From: Robert Steele [REDACTED]
Sent: 14 October 2016 09:29
To: David Innes
Cc: Stuart Garnett
Subject: RE: LU/201/16/RES Windroos - draft changes to masterplan

From: David Innes [<mailto:David.Innes@arun.gov.uk>]
Sent: 12 October 2016 11:59
To: Robert Steele
Subject: RE: LU/201/16/RES Windroos - draft changes to masterplan

TITLE PROPOSED SITE PLAN - SHEET 2 OF 2

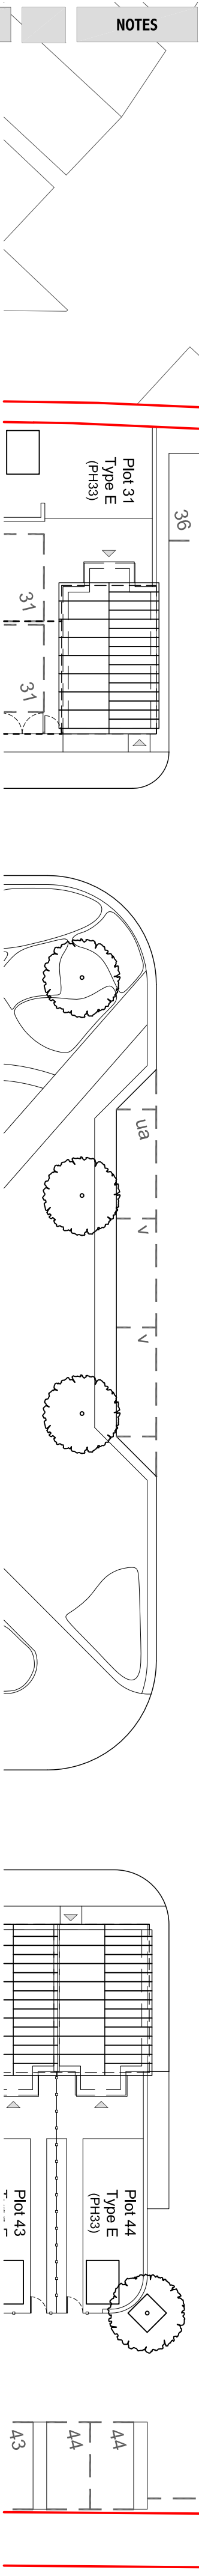
The points I raised in the meeting have not been taken on board in this sketch layout. There is very little change to the layout overall which is still characterised by a cramped development with too many car courts. A number of properties are fronting gable walls with very little distance between properties.

Plot 32 mews poor attempt to resolve the parking security issue. End up with a contrived house design in this location.

Plot 33 – facing gable of 31

Plots 48 & 49 facing gable

Plots 67 & 68 fronting gable

Parking court spaces 66-72

Parking court north of flats

CLIENT	STUART & MARCIA LYONS
PROJECT	WINDROOS, LITTLEHAMPTON
TITLE	2 BEDROOM FLATS - FLOOR PLANS

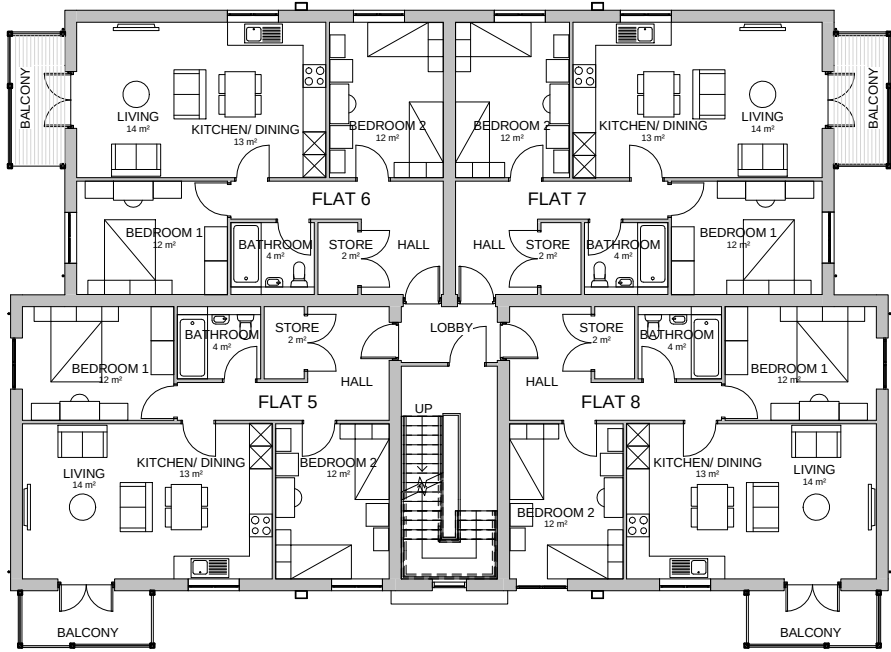
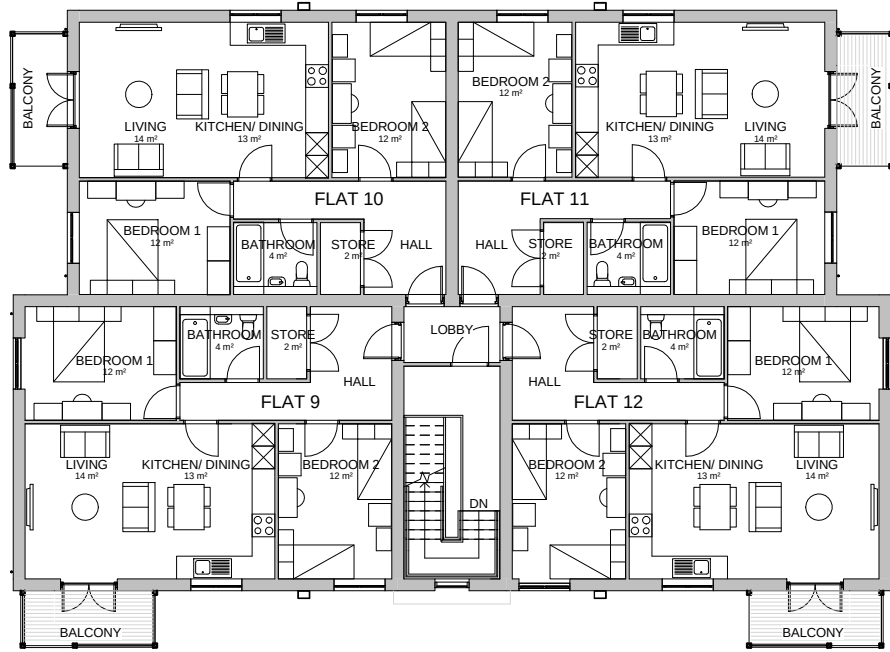
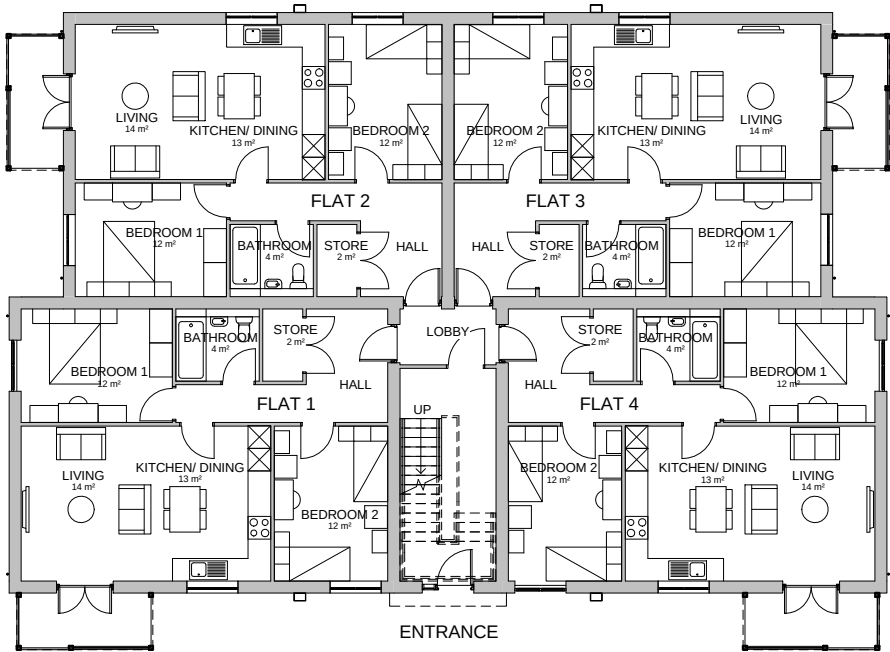
Flats still too close to the boundary given the boundary is shared with an industrial area service road.
